March 4, 2024
File: 121625708

Reference: Geotechnical review of the proposed Grading Plan and Landscaping Plan (regarding the City of Ottawa Tree Planting in Sensitive Marine Clay Soils policy) for the Proposed St. Patrick's Home of Ottawa Building

DRAWING TITLE/TITRE DU DESSIN  
**GRADING PLAN**

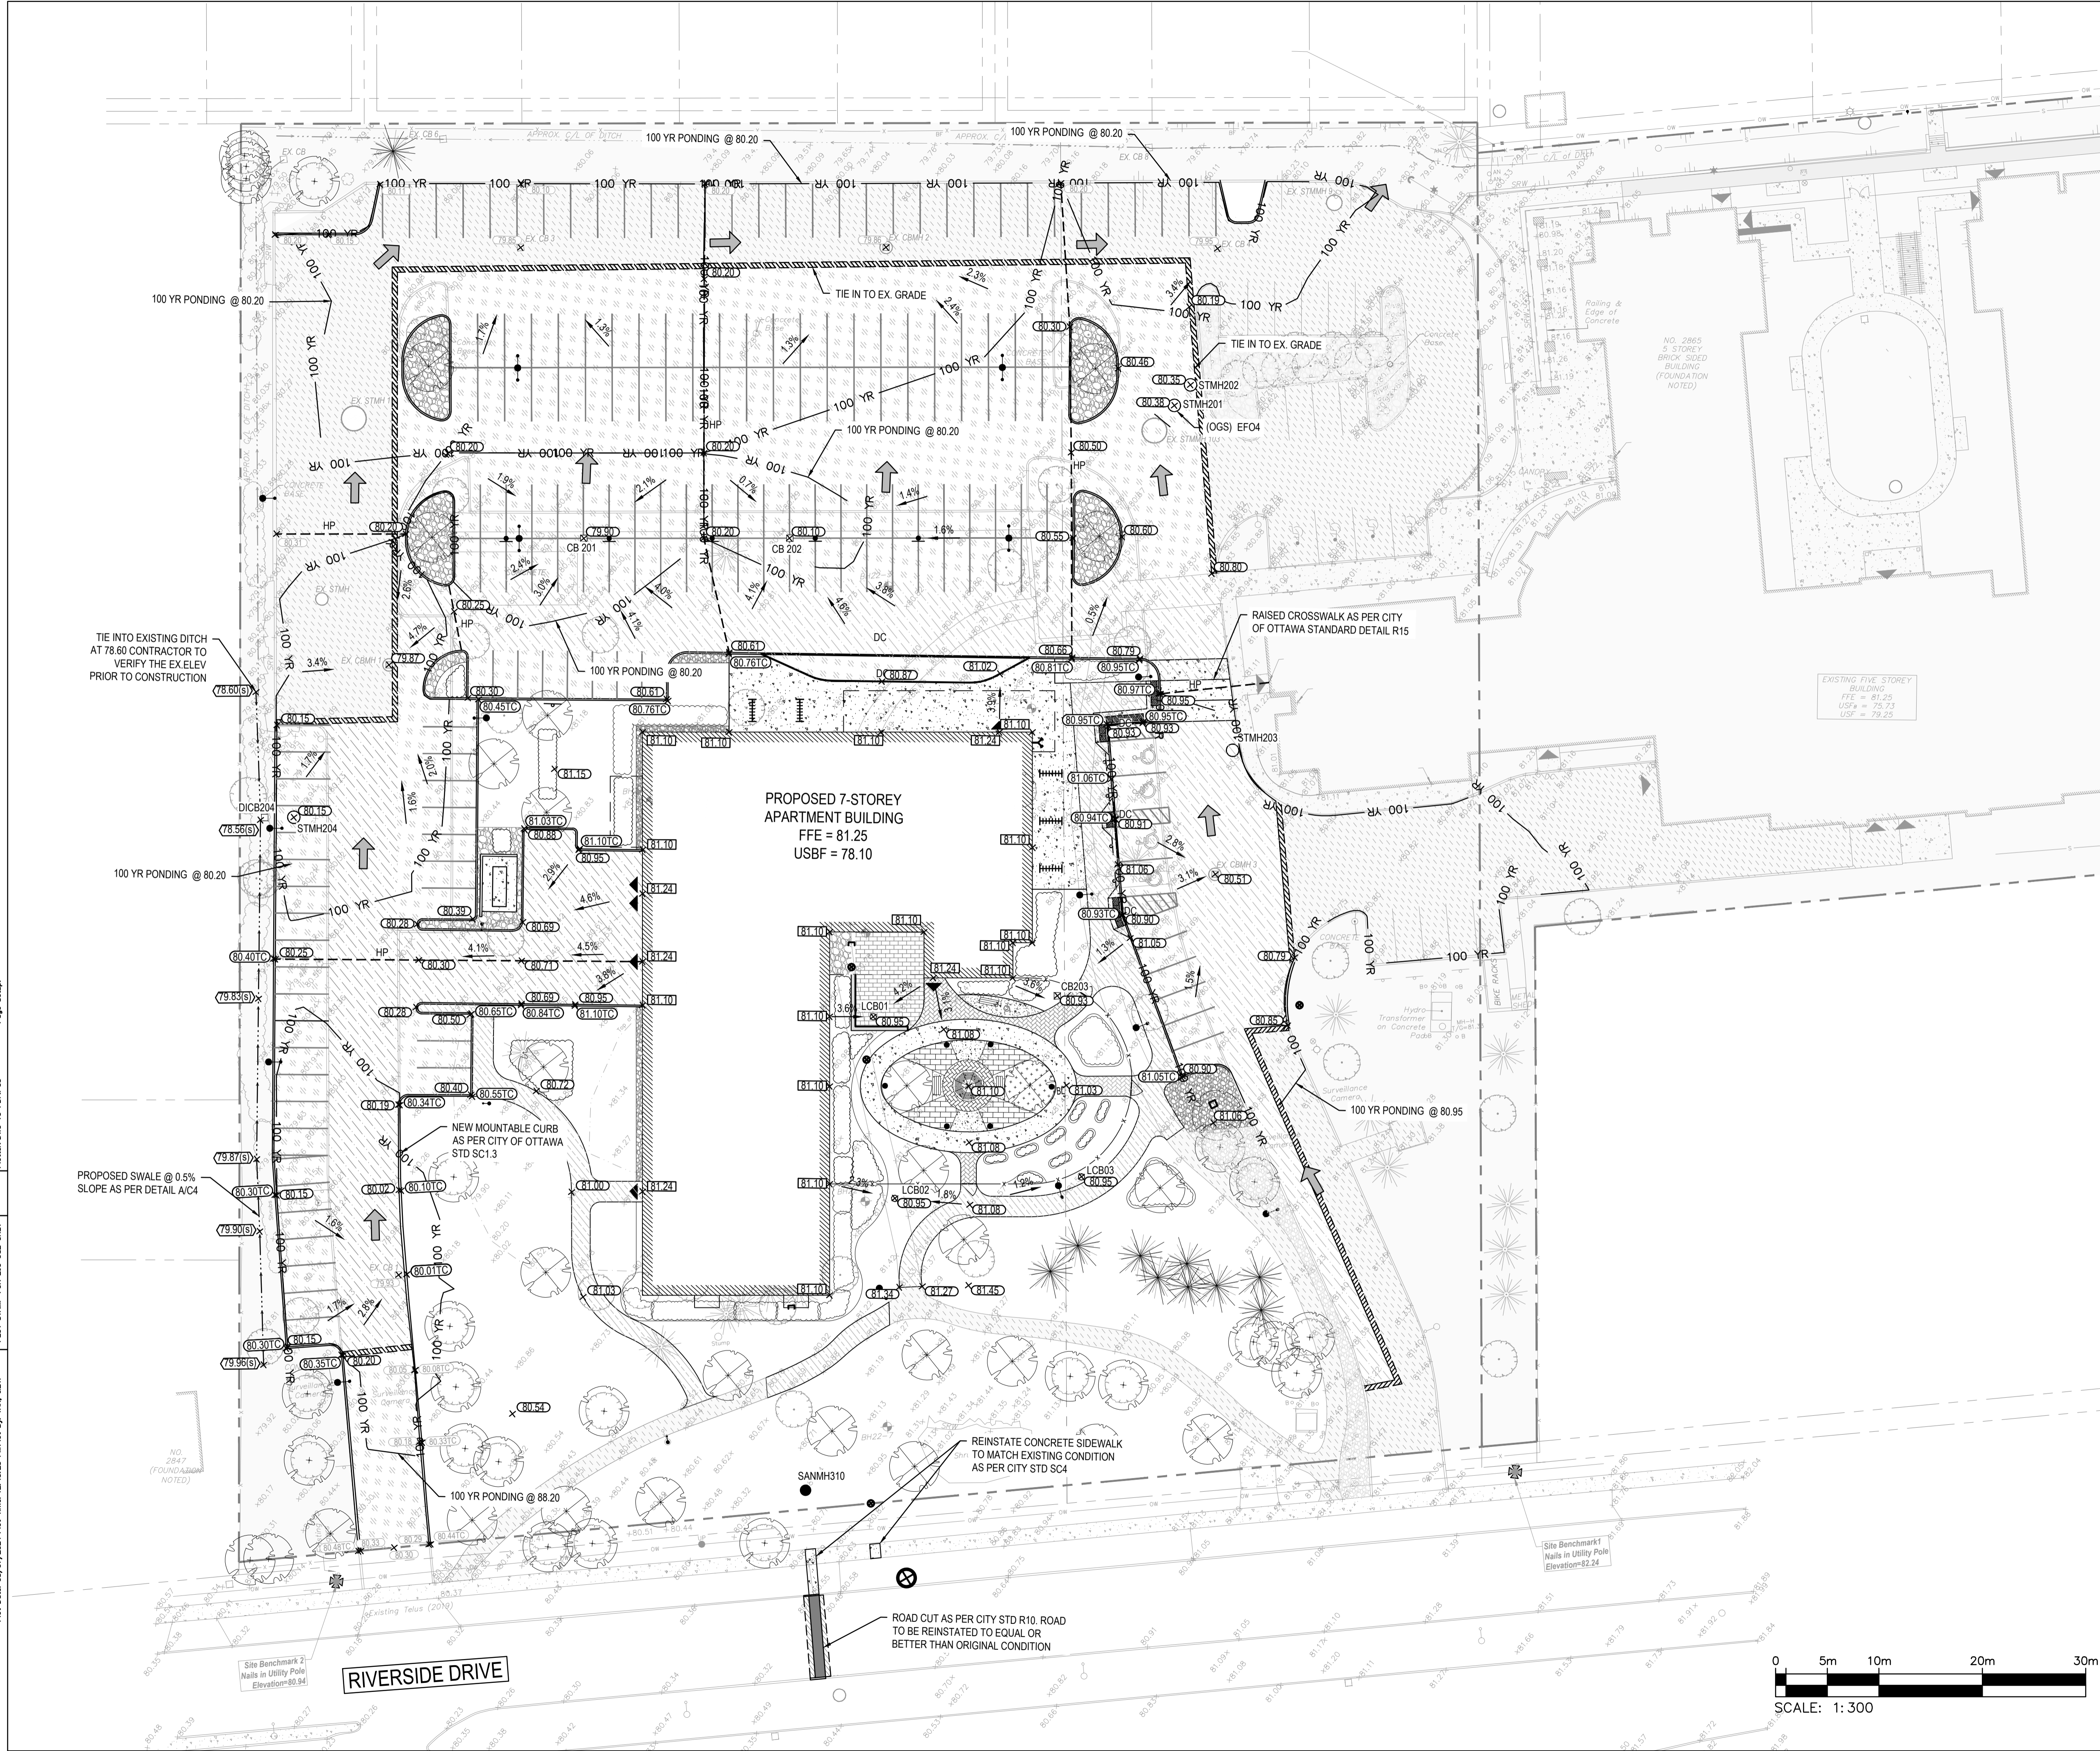
Based on the geotechnical investigation report prepared by Stantec, the site is underlain by a compressible Champlain Sea clay deposit that is approximately 1.5 to 3.8 m thick and a maximum grade raise restriction of 2 m was recommended for the development due to the compressible soils encountered at the site.

Based on a review of the Grading Plan, the proposed grade raise across the site is significantly less than 2 m and is acceptable from a geotechnical perspective to limit ground surface settlements at the site.

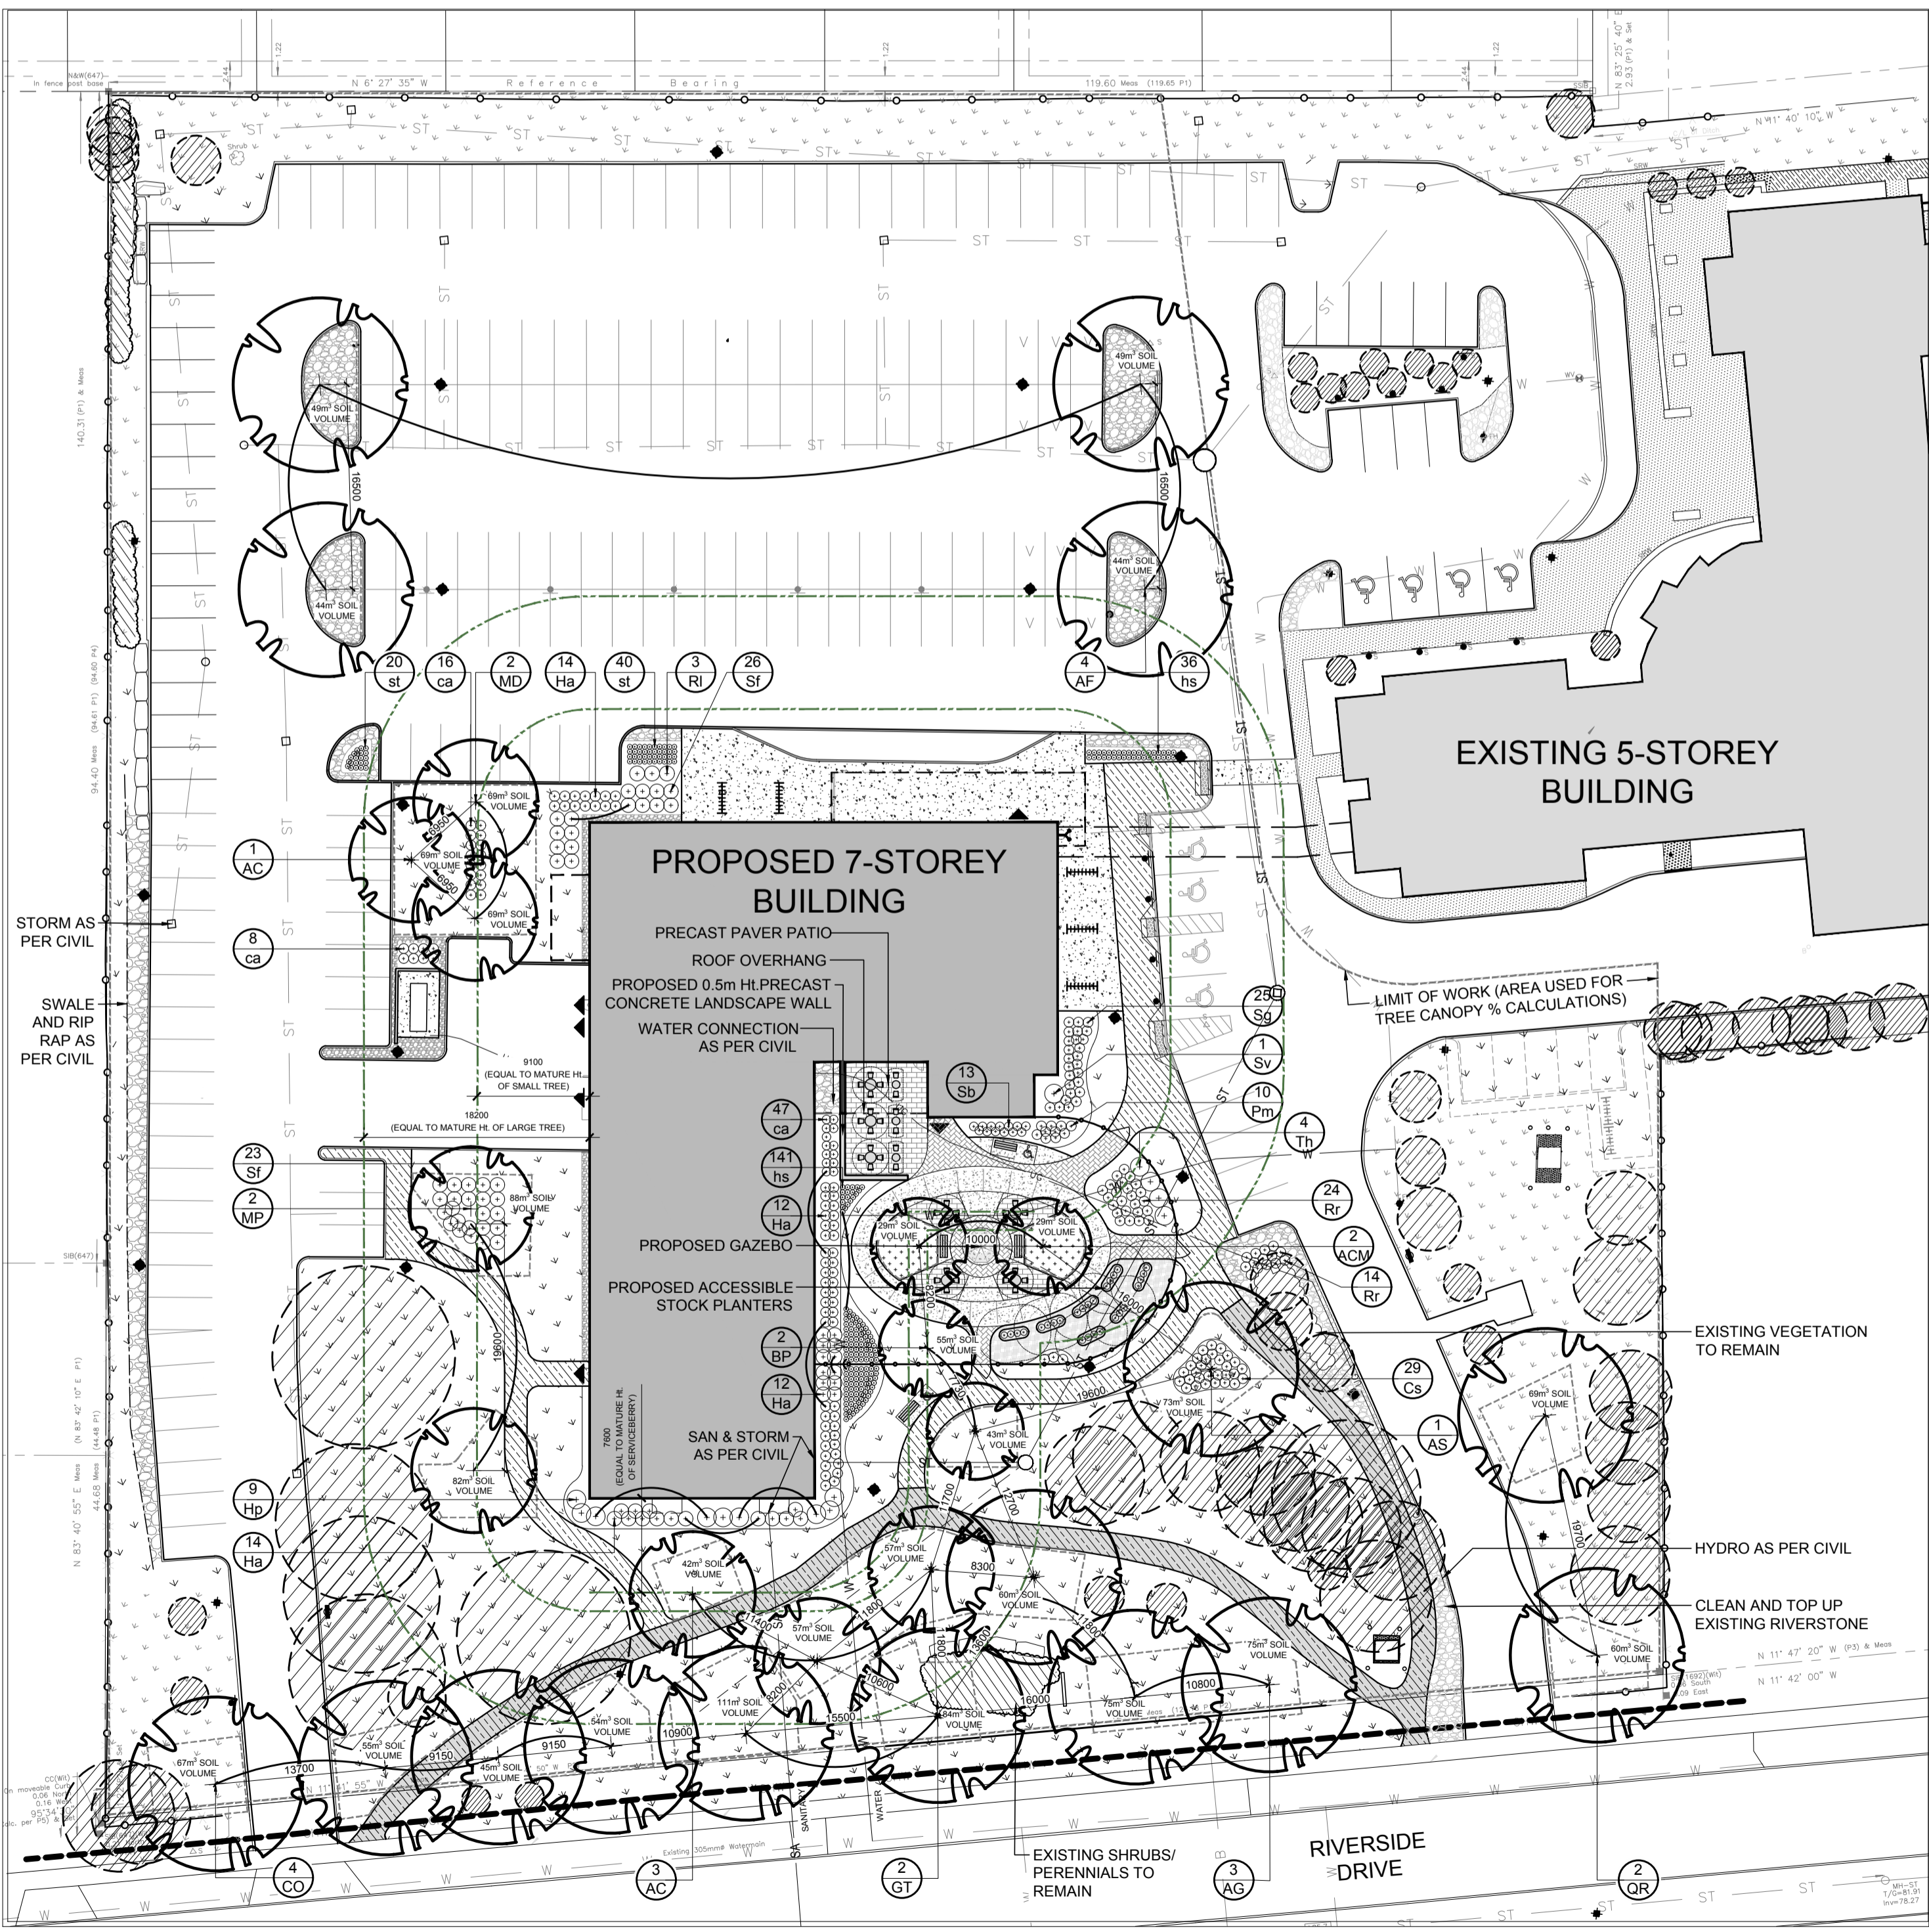
When planting trees on City property where sensitive marine clay soils are known to exist, the tree must be planted at a distance from a building foundation or structure equivalent to the full mature height of the tree.

Based on *City of Ottawa Tree Planting in Sensitive Marine Clay Soils - 2017 Guidelines* where Sensitive Marine Clay (SMC) soils have been identified, the tree to foundation setbacks may be reduced to 4.5 m for small (mature tree height up to 7.5 m) and medium size trees (mature tree height 7.5 m to 14 m) provided certain conditions are met. Validity of these conditions at the site is discussed in the following table.

3. A small size tree must be provided with a minimum of 25 m ³ of available soil volume, as determined by a Landscape Architect. A medium-size tree must be provided with a minimum of 30 m ³ of available soil volume, as determined by a Landscape Architect. The developer will ensure the soil is generally uncompacted when backfilling in street tree planting locations.	All trees are provided with more than 35 m ³ of available soil volume with the exception of two Multi-stem Gray Birch (<i>Betula populifolia</i> 'Multi-stem'), which each have 29 m ³ of available soil volume. Considering Multi-stem Gray Birch as a medium-size tree, the available soil volume for each tree should be increased to 30 m³.

4. The tree species is to be of very low to moderate Potential Subsidence Risk, as listed in the Street Tree Manual for Greenfield Neighbourhoods, in order to reduce the risk of negative impacts on SMC soils.	The proposed tree species in the landscaping plan all fall under very low to moderate category for potential subsidence risk with the exception of <i>Quercus rubra</i> (Red Oak). The proposed <i>Quercus rubra</i> (Red Oak) trees should be replaced with a tree with very low to moderate potential subsidence risk, as listed in the Street Tree

Conditions to Reduce the Tree to Foundation Setbacks	Validity Of the Condition at Site
	<p>Manual for Greenfield Neighbourhoods, in order to reduce the risk of negative impacts on SMC soils. It is noted that recent studies on various oak species have reported them as being more drought tolerant in part because of their ability to carry water and nutrients from the roots to the leaves even during severe droughts, while for most other trees the water flow is obstructed by air bubbles forming when the capillary tensions become too great. This would indicate that during extreme droughts (such as experienced in 2021) oak trees would continue to extract water from the matrices of the clays, while less tolerant trees would become dormant.</p> <p>In view of the recent severe droughts that have occurred in the area, Stantec's geotechnical engineers recommend that a <i>foundation setback reduction</i> should not be considered applicable the red oak, or to other oak trees.</p>

6. Grading surrounding the tree must promote draining to the tree root zone (in such a manner as not to be detrimental to the tree), as noted on the subdivision Grading Plan.	The landscape architect should review the site grading plan to confirm that this objective is satisfied in areas where the <i>foundation setback reduction</i> is being applied.
